Consultants Advice Notice

Project:	Ardex Australia SEPP 33	Ref No.:	RCE-21117
From:	Lucy Jimenez	Date:	9/02/2022
	Steve Sylvester	Revision:	0
Attention	Company	Email	
To:	Cameron Gray	Willow Tree Planning	cgray@willtp.com.au
RE: ARDEX Warehouse and Manufacturing Facility (SSD-25725029)

1.0 Response to Comments from DPIE

Figure 3-1: Proposed Site Layout

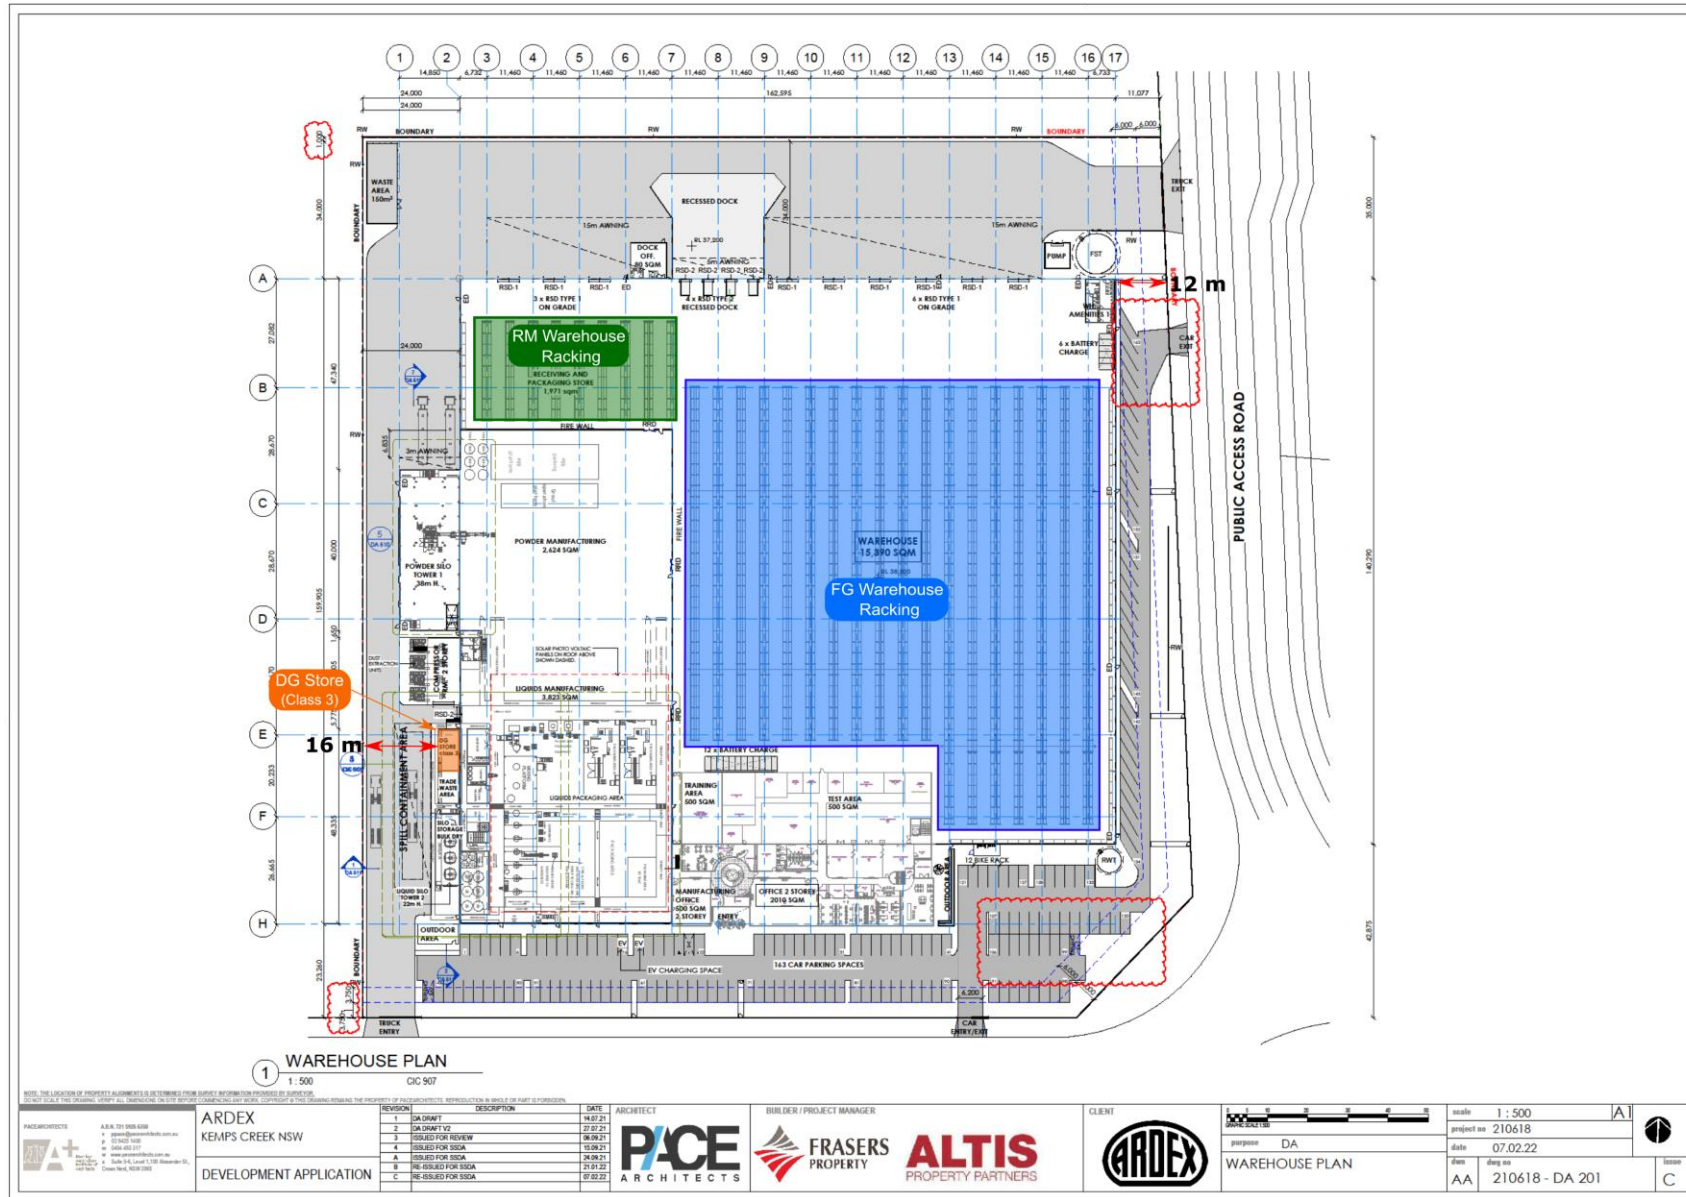
No.	Comment	Response
1.a.	The Department highlights that there were inconsistencies in separation distances used for preliminary risk screening of flammable liquids in the SEPP 33 Report. On page 6 of the SEPP 33 Report, describes 9 metres separation for risk screening of flammables. In Figure 3-1 of the SEPP 33 Report, the smallest distance is 12 metres to site boundary and in Figure 3-4, 16 meters separation is applied for preliminary risk screening. As such the Department is unclear on validity of the preliminary risk screening of flammable liquids given the smallest separation from the warehouse to the site boundary is 12 metres.	The report has been corrected such that the assessment of flammable liquids has been conducted using a separation distance of 12 m. Please note that in the review process, the quantity of Class 3 DGs to be stored has been reduced. The original DG storage quantities were based on Ardex acquiring a business which required the storage of a range of DGs similar to the DGs stored, handled and processed by Ardex. This business venture is no longer being pursued and, hence, the quantities of DGs have been reduced to those listed in the updated SEPP33 study.

No.	Comment	Response
1.c.	The Department seeks clarification on whether any of the Class 9 or other hazardous materials are defined as a combustible liquid C1 (as classified by AS 1940) and stored at the proposed development. We request the Applicant provide any quantity of combustible liquid C1 to be stored at the proposed development. As per “Applying SEPP33”, page 16, where combustible liquids C1 are kept within a store with flammable liquids they are treated as DG Class 3 PGIII and must be added to the flammable liquids’ quantity when undertaking the preliminary risk screening	A review of the SDS of the Class 9 DGs indicates that no combustible liquids (C1) will be stored.
2	The proposed development will incorporate an office space. The Department highlights that these offices would be classified as an on-site protected place by Australian Standards for the handling of DGs. The Department seeks information on separation of the warehousing areas (containing DGs) to the offices, noting the requirements of Australian Standards for storage and handling DGs.	<p>DGs will be stored in the Class 3 Store, in the Raw Materials (RM) warehouse and in the Finished Goods (FG) warehouse. The required separation distances are as follows:</p> <ul style="list-style-type: none"> • <u>Class 3 DG Store</u>: 10 m separation is required as per Table 4.1 of AS 1940–2017. • <u>FG/RM Warehouse</u>: As only manufactured products in retail-size packages are stored in this area, it has been classified as a retail distribution centre (RDC) under AS/NZS 3833:2008. RDCs do not have specified separation distances to protected places. However, as per Clause 3.2.5(e) of the standard, the walls of the warehouse adjacent to offices shall be constructed of fire walls with an FRL of 60/60/60. <p>As shown in Figure 1-1, these separation distances have been met.</p>
